Portishead Branch Line (MetroWest Phase 1)

TR040011

Applicant: North Somerset District Council
8.1 Addendum to the Design and Access Statement

Author: Jacobs / Womble Bond Dickinson LLP
Version: 1
Date: September 2021

467470.BQ.04.20-100 X

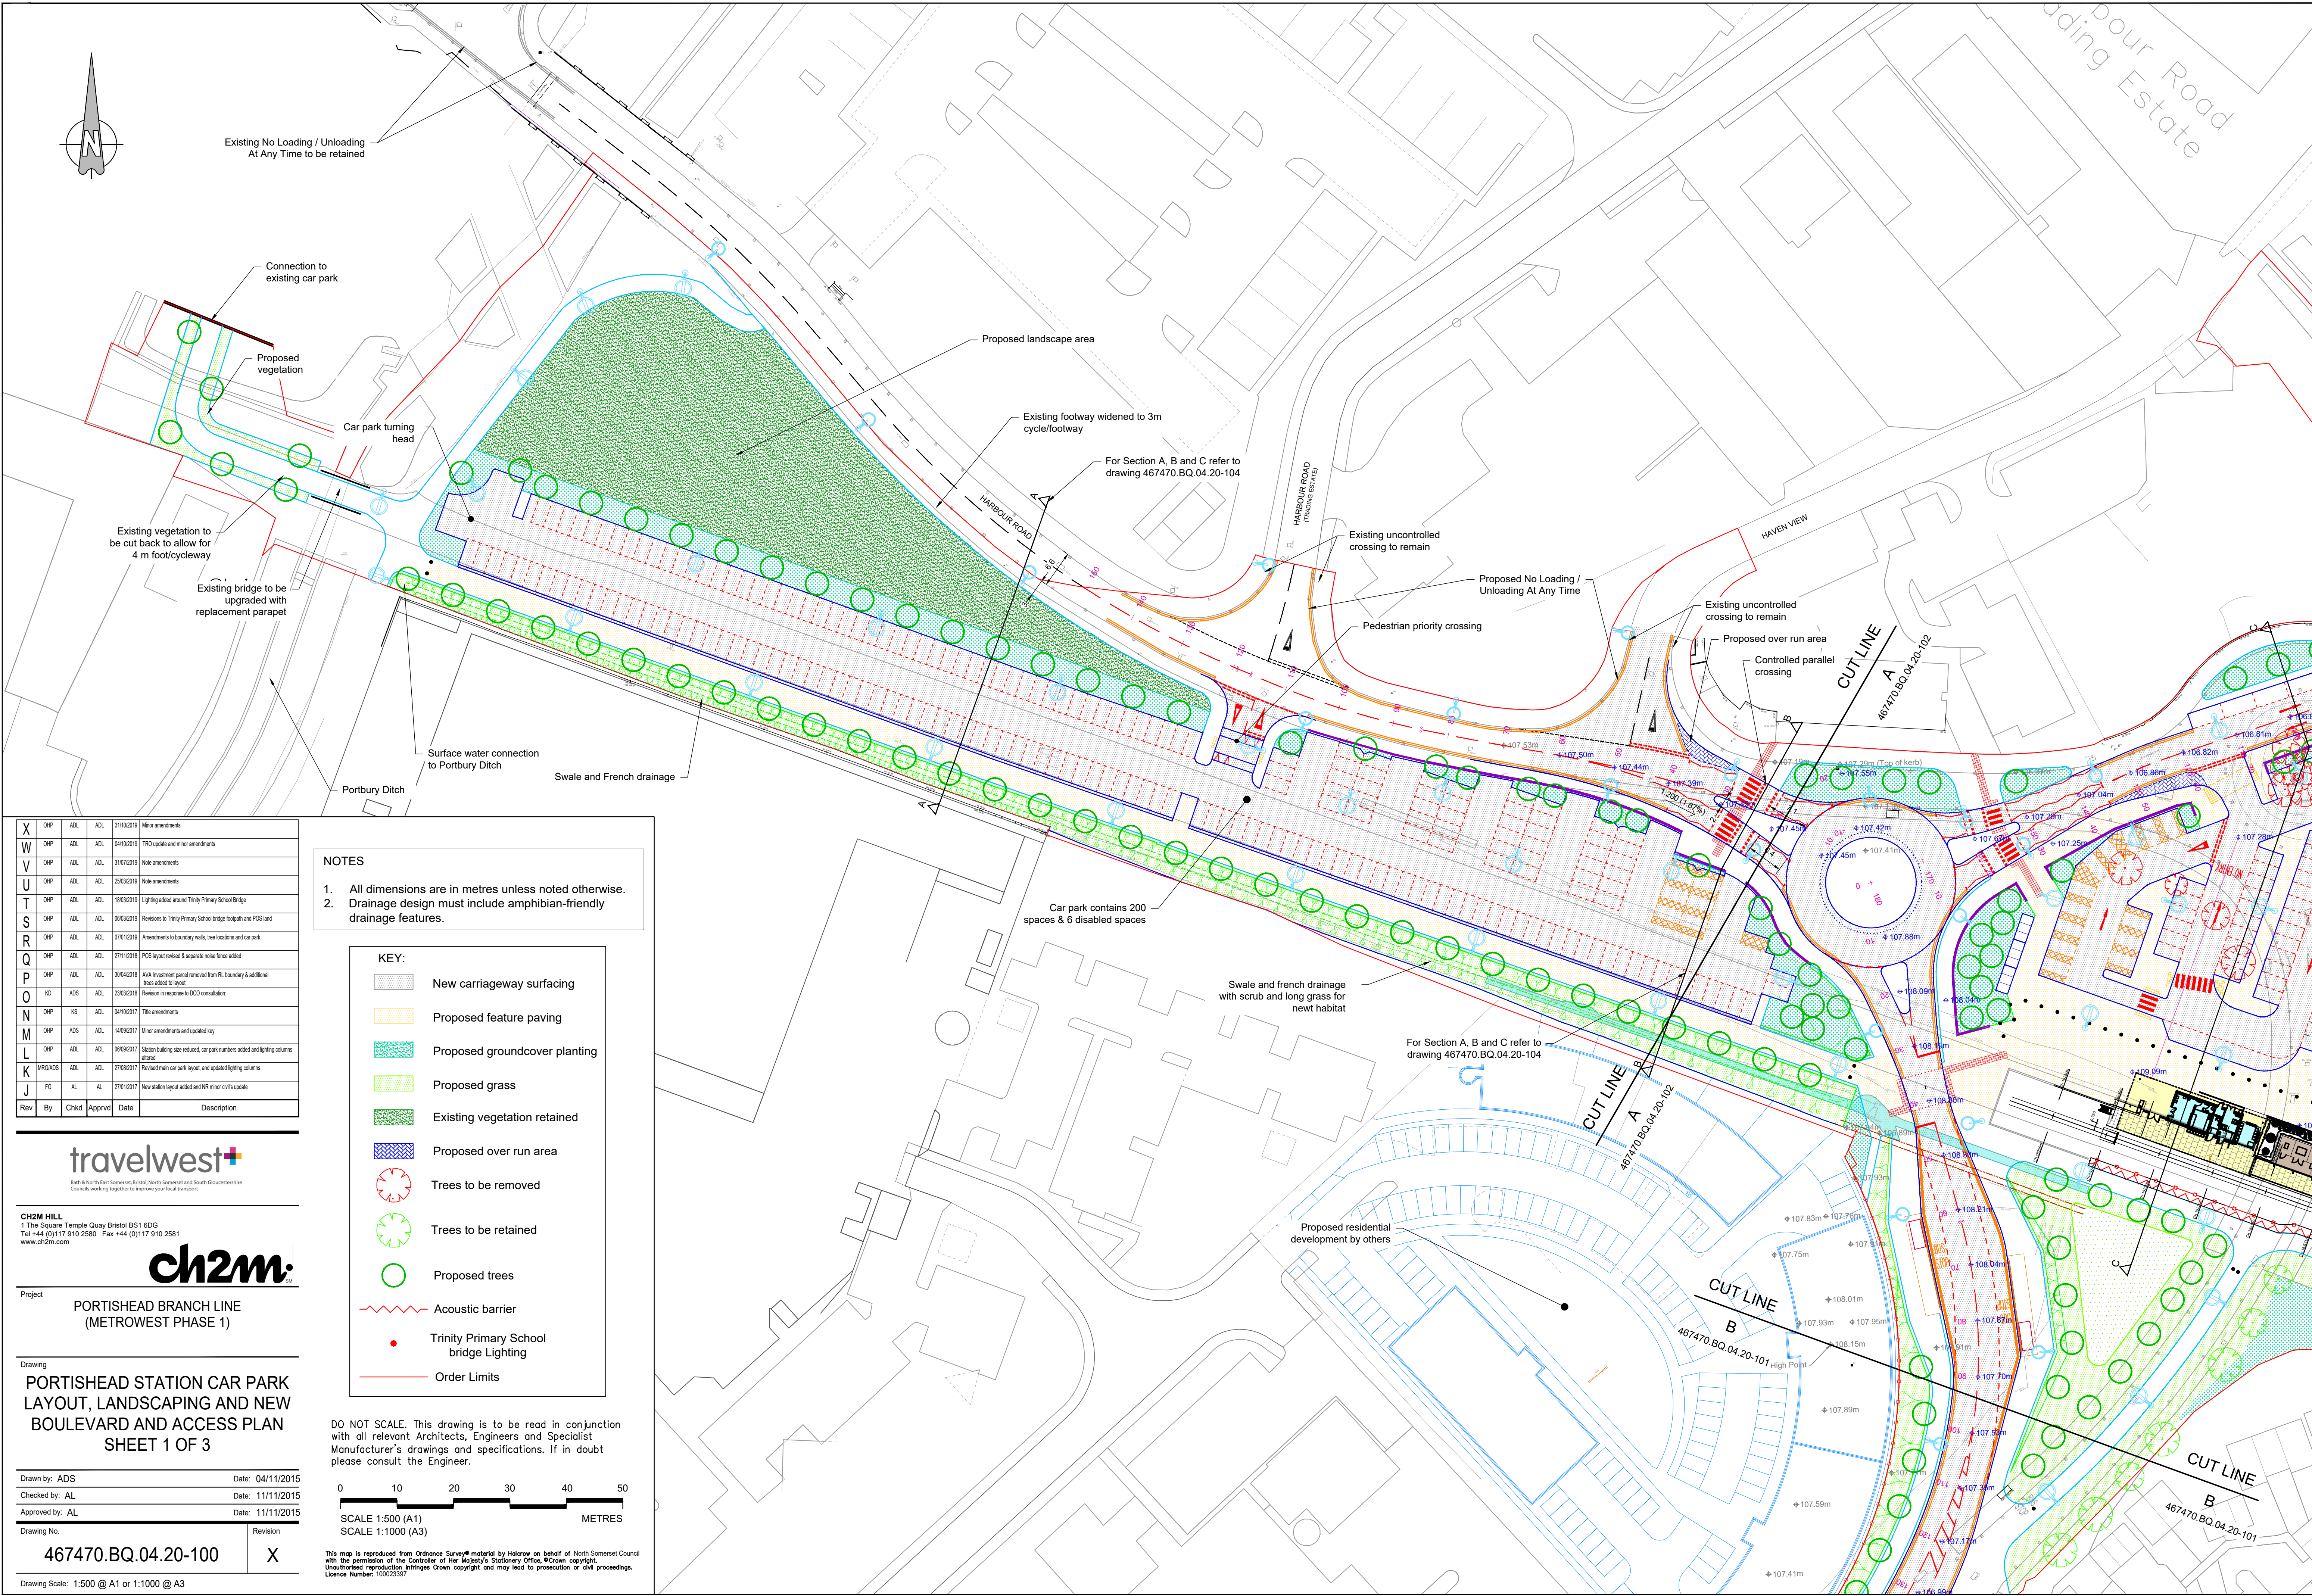
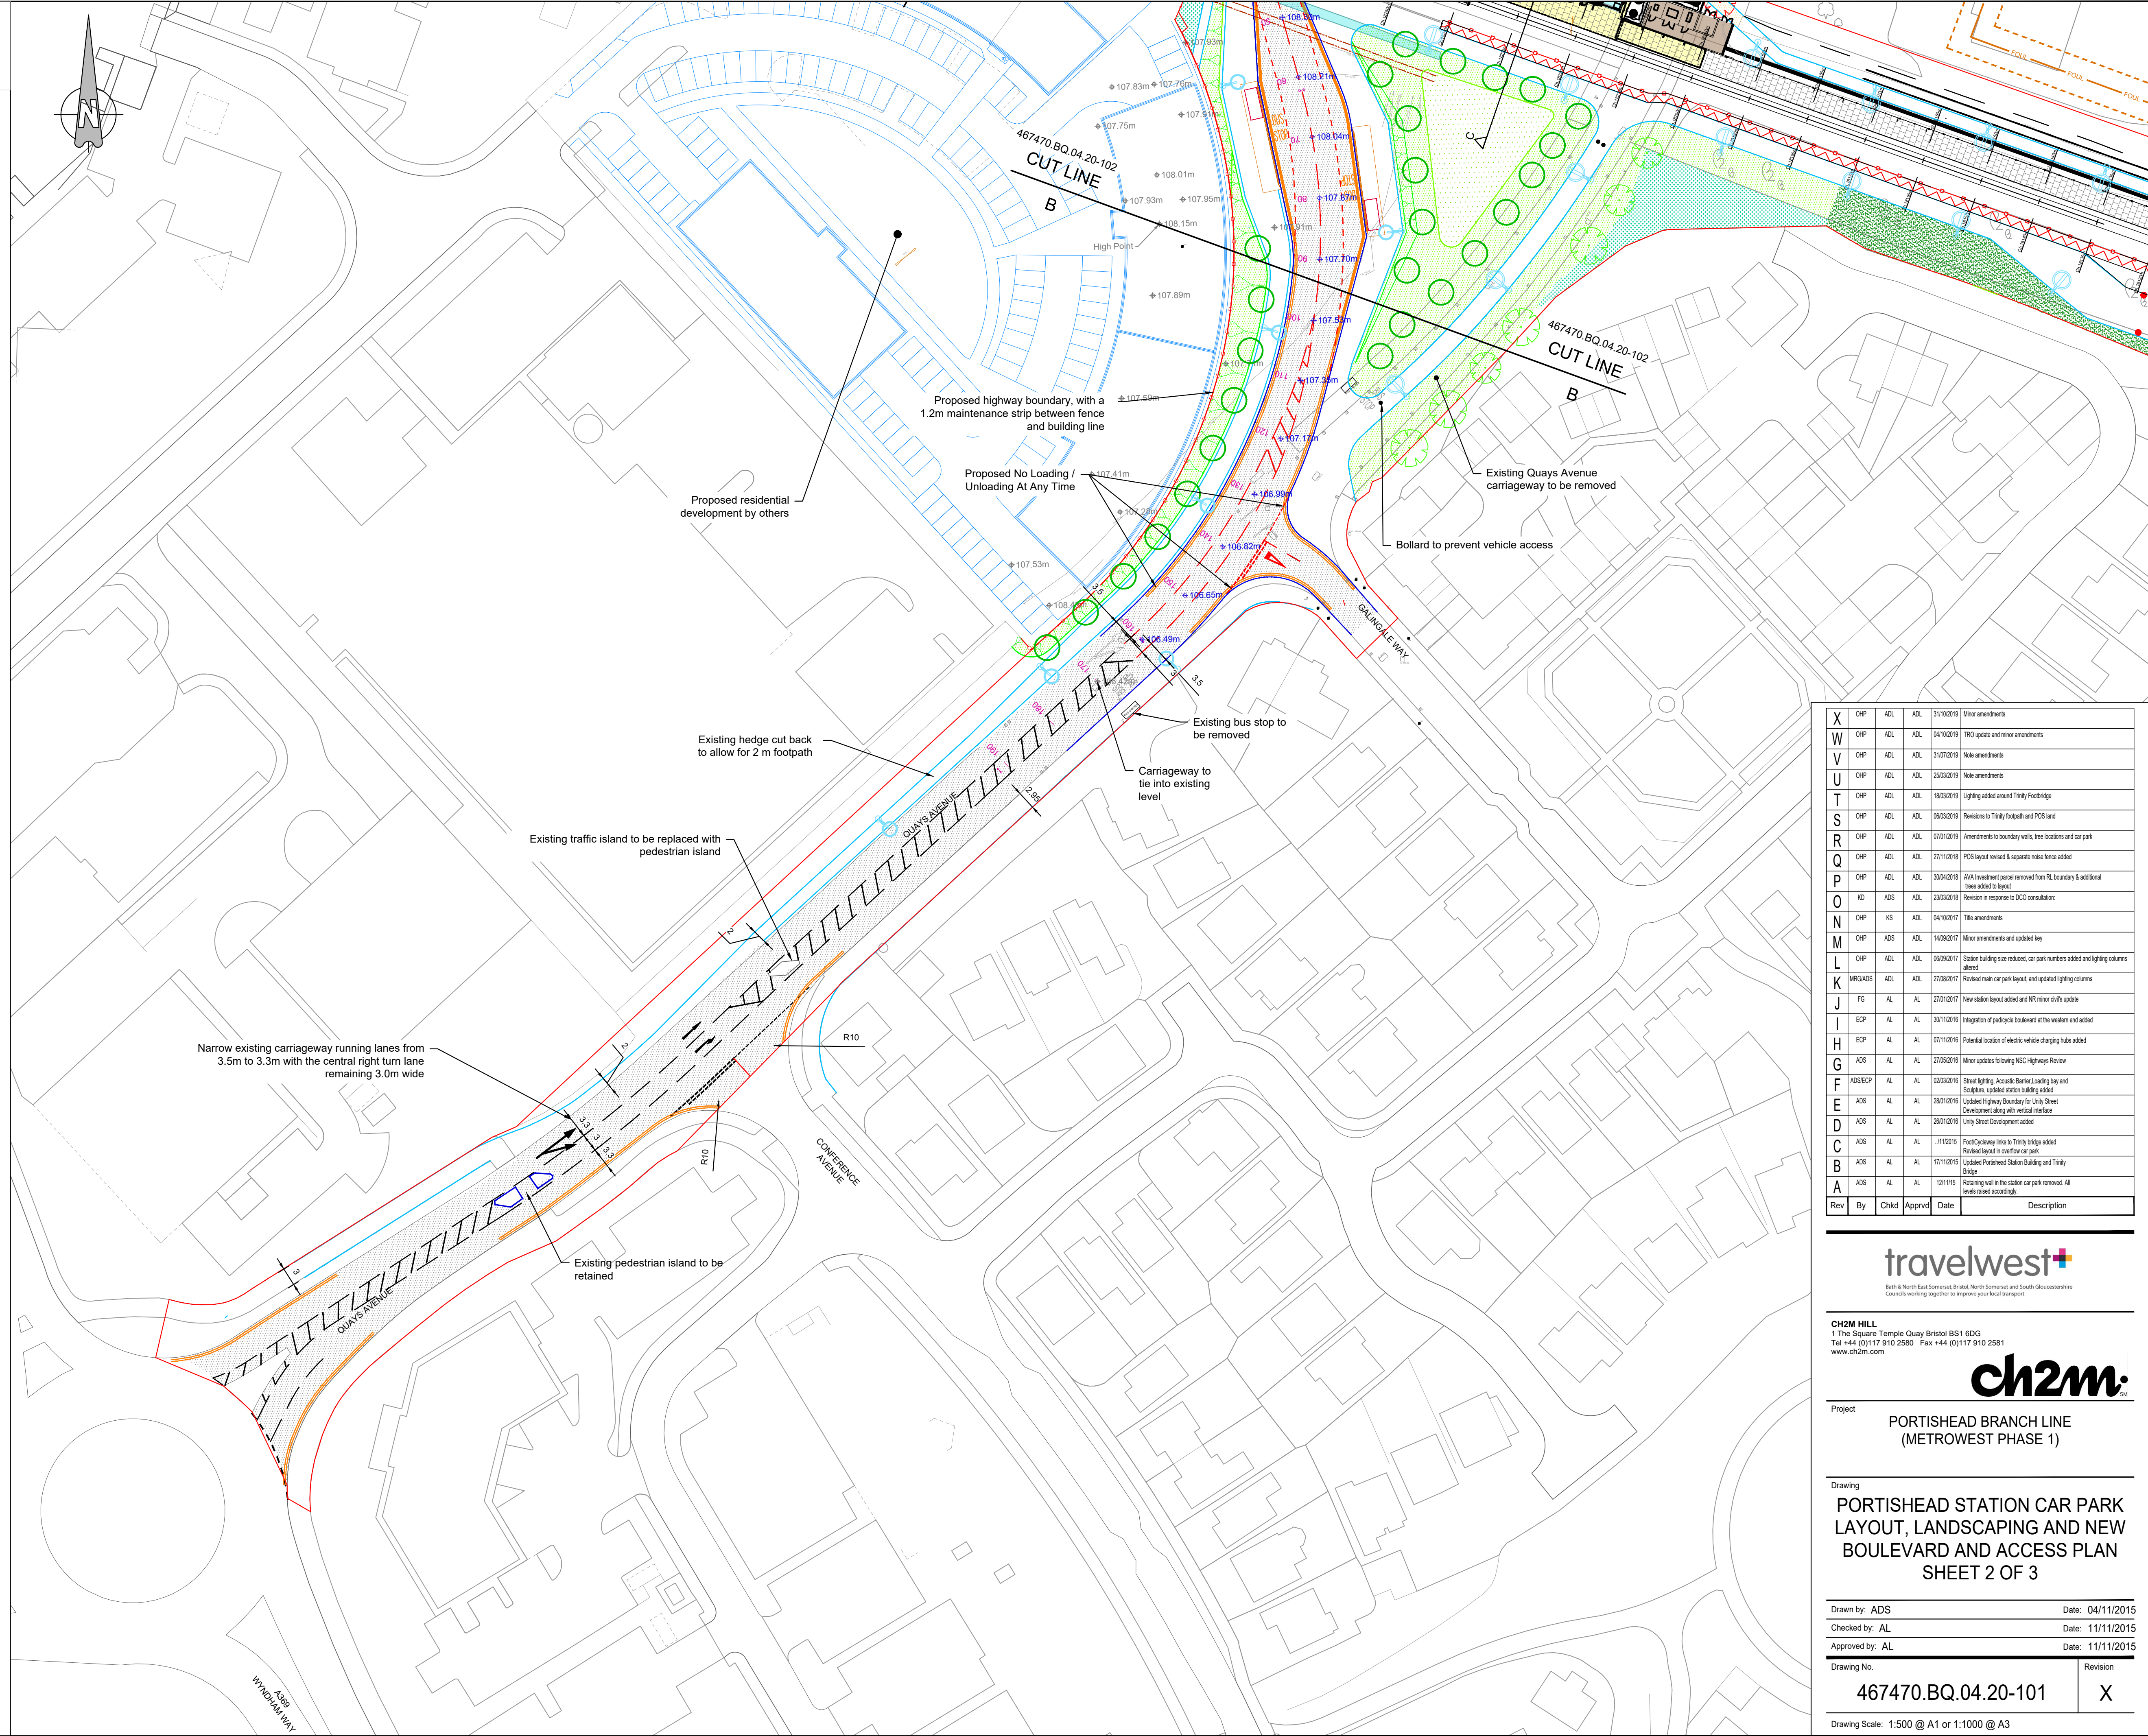
- 2.9. Paragraph 20.13 has been removed.
- 2.10. Figure 30 is replaced with the latest version of drawing 467470.BQ.04.20-100 rev AA.
